MEMORANDUM

DATE: May 12, 2023
TO: Kacey Simon, Civil Plan Reviewer
FROM: Emily Morgan, Senior Planner
RE: Brodie Rezone PRD – Civil Review 3 (PA22-023 / G22-0054)
CC: Chris Holland, Planning Manager
Ken McIntyre, PE, Assistant City Engineer

SP-01
 SHEET 4 OF 14

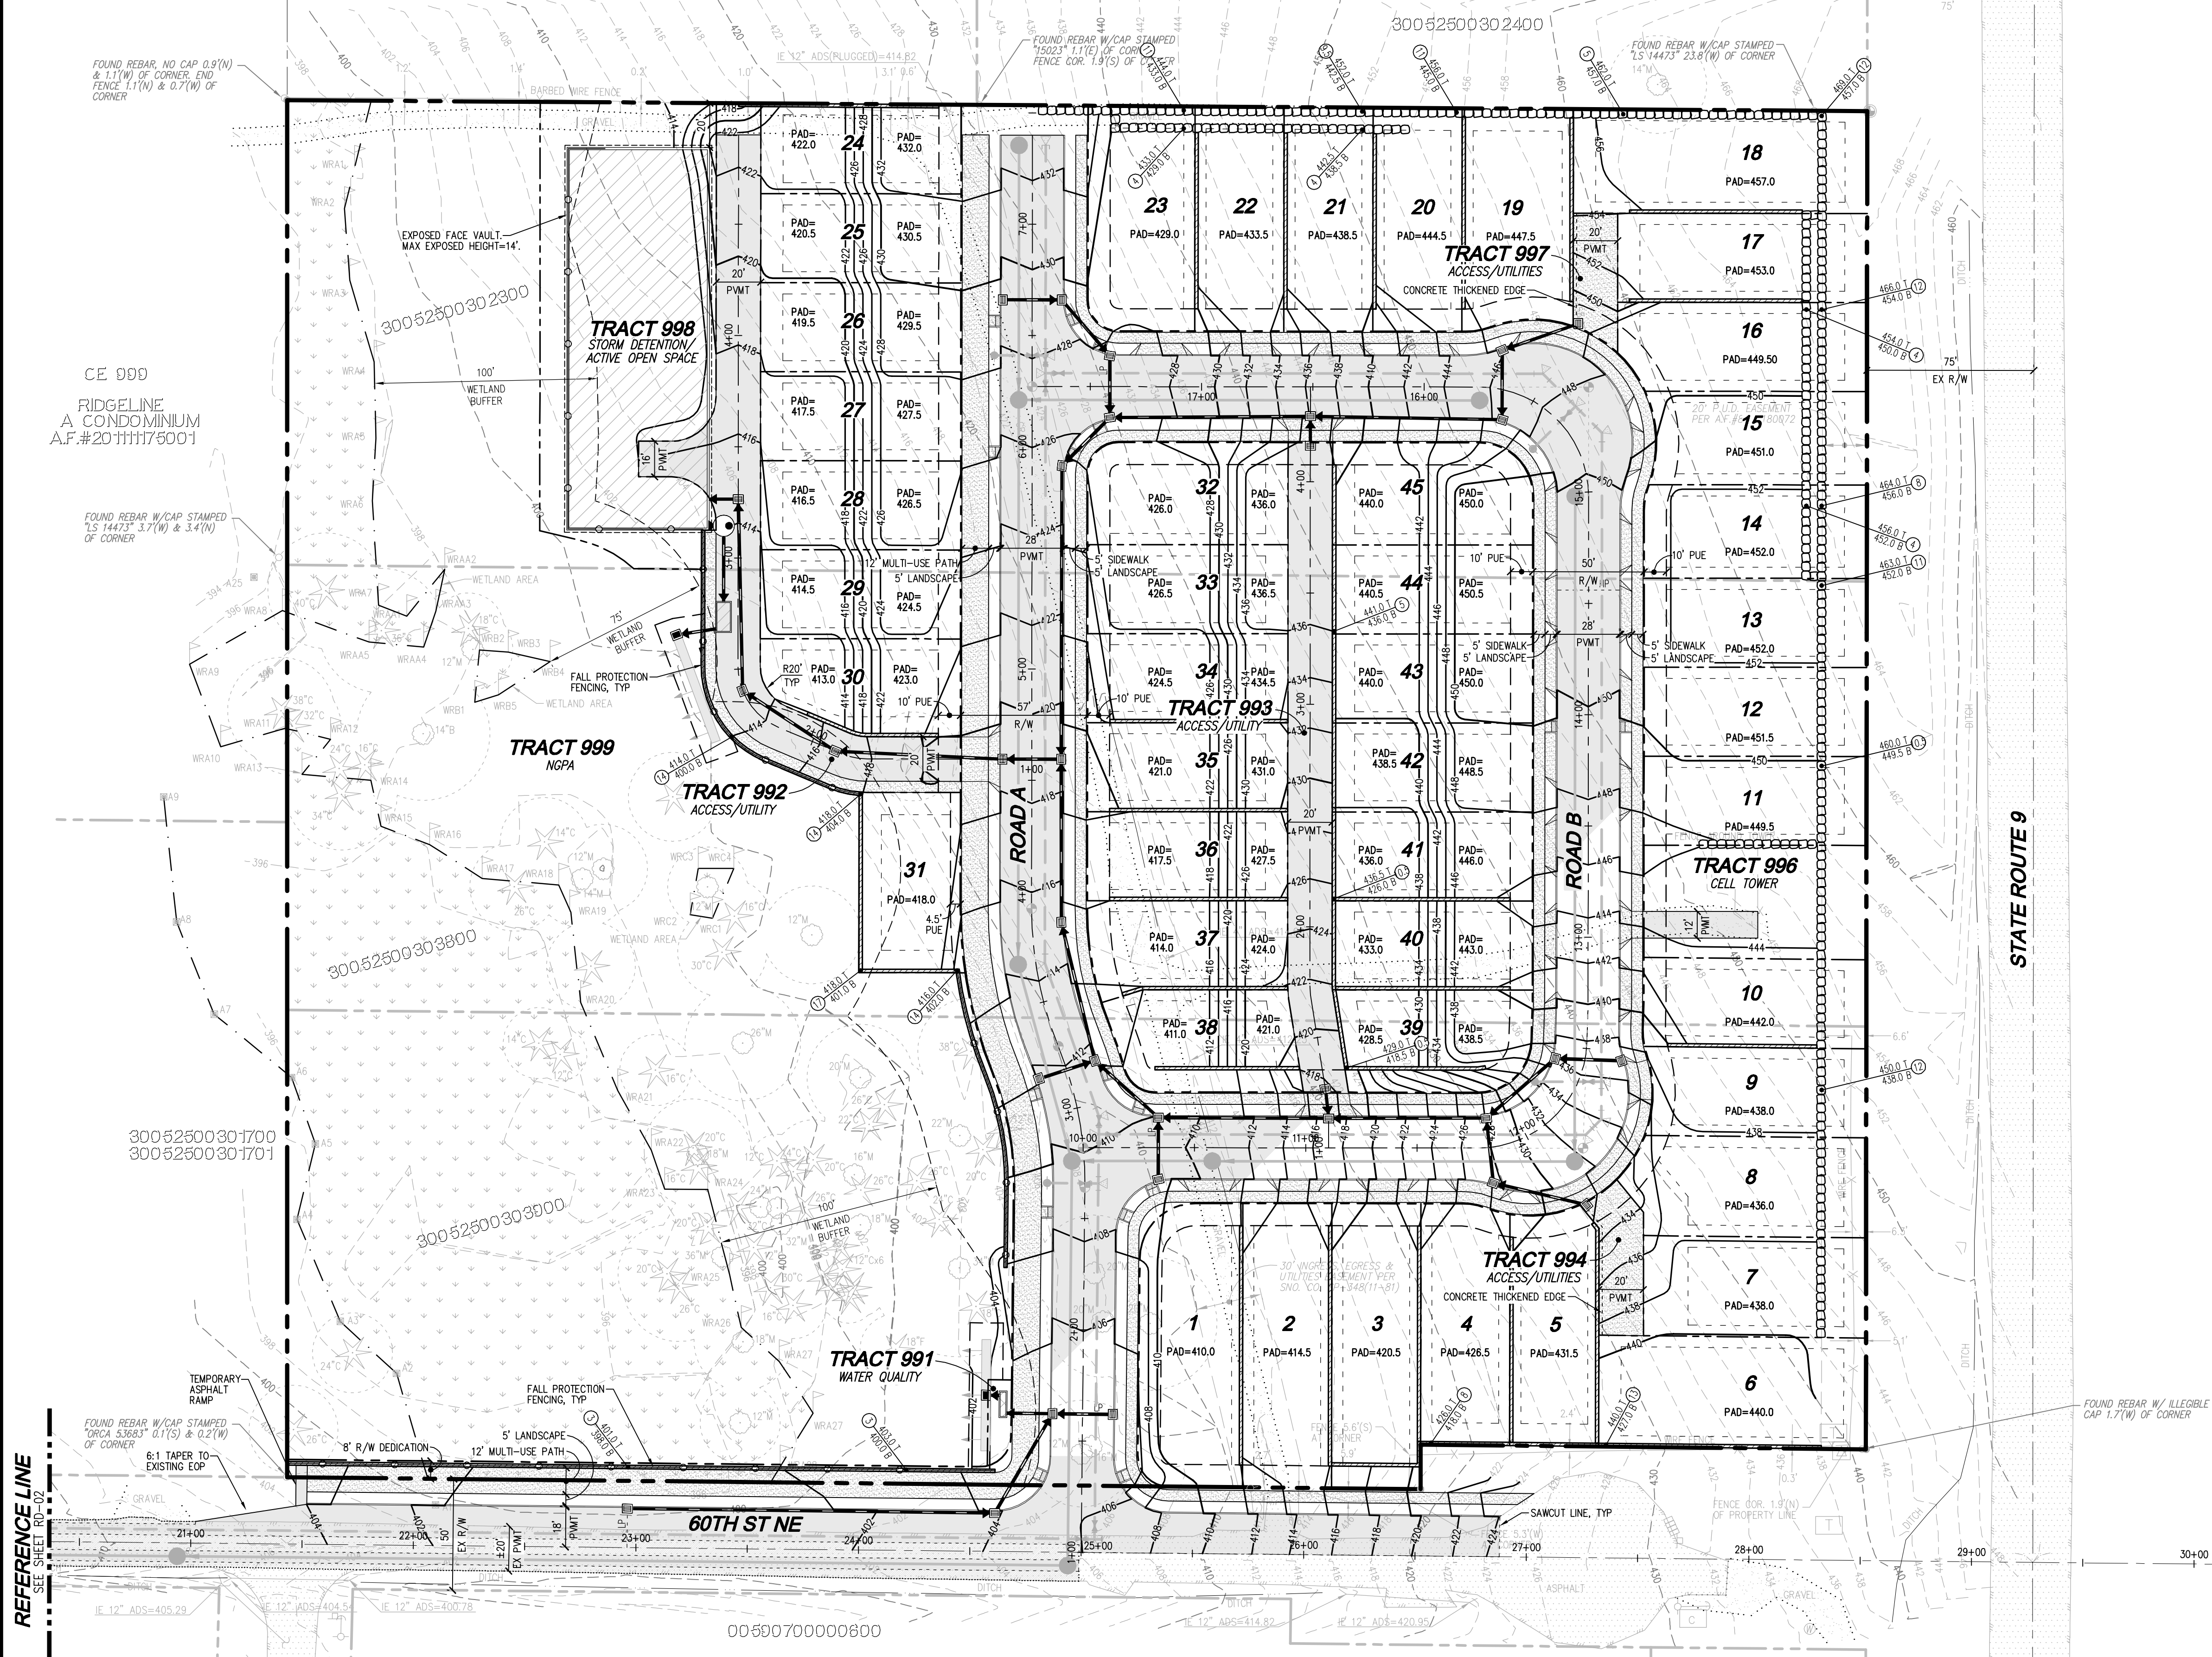
1. Based on the plan sets, there is to be a pervious pathway located along the outer edges of Tract 999. Revise Civil and Landscape plans to include the pedestrian trail connection (shown as highlighted below) to another pedestrian trail/sidewalk rather than dead ending.

2. The details for the Active Open Space of Tract 998 is a bit lacking. The proposed large amenity play structure (specs shown on Sheet L-6 of the Landscape Plan) does not appear to meet the standards of MMC 22G.080(2)(h)(ii). Provide details of Tract 998, in its entirety, on a single page.
3. Staff has reviewed and concurs with the findings in the revised Critical Area Study and Buffer Mitigation Plan prepared by Wetland Resources, Inc., dated April 26, 2023.
